DECISION DELEGATED TO DEVELOPMENT MANAGER

Application No: H01-0998-18 **Applicant:** Mr R Turner
Proposal: Extensions and alterations - re-submission of H01-0744-18
Location: Fairview Farm 19 Mill Drove South Cowbit
Terminal Date: 30th November 2018

Elevation 03 - Rear

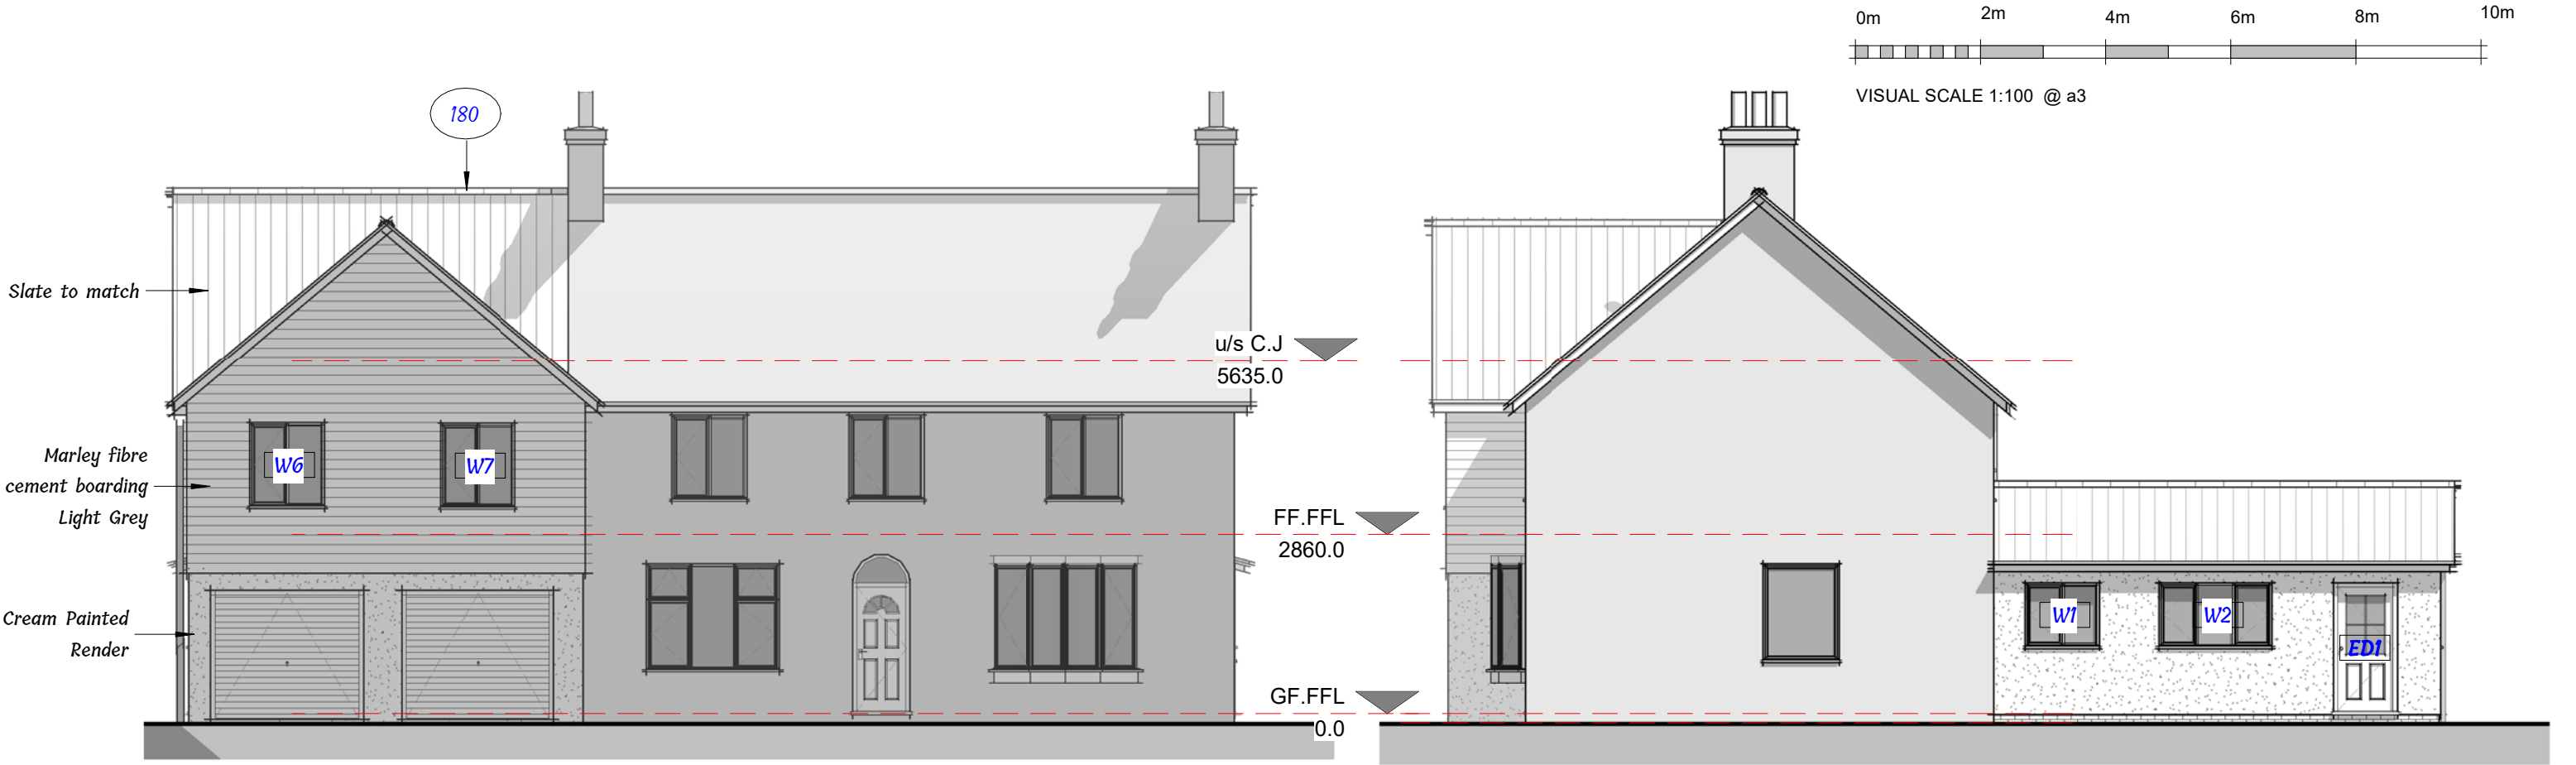
The aim of this new proposal is to seek permission for replacing flat roof on top of single-storey rear extension for gable roof.

Two gable pitches instead of single pitch are proposed in order not to block the rear windows on the first floor level and undermine the potential amenity of dwelling occupiers.

This amendment would soften the "sharpness" of a flat roofed extension which was not unacceptable although the new roof feature would actually embellish the external layout and design without detracting from the existing host property and properties nearby.

The roof tiles would be still matching those existing in the property.
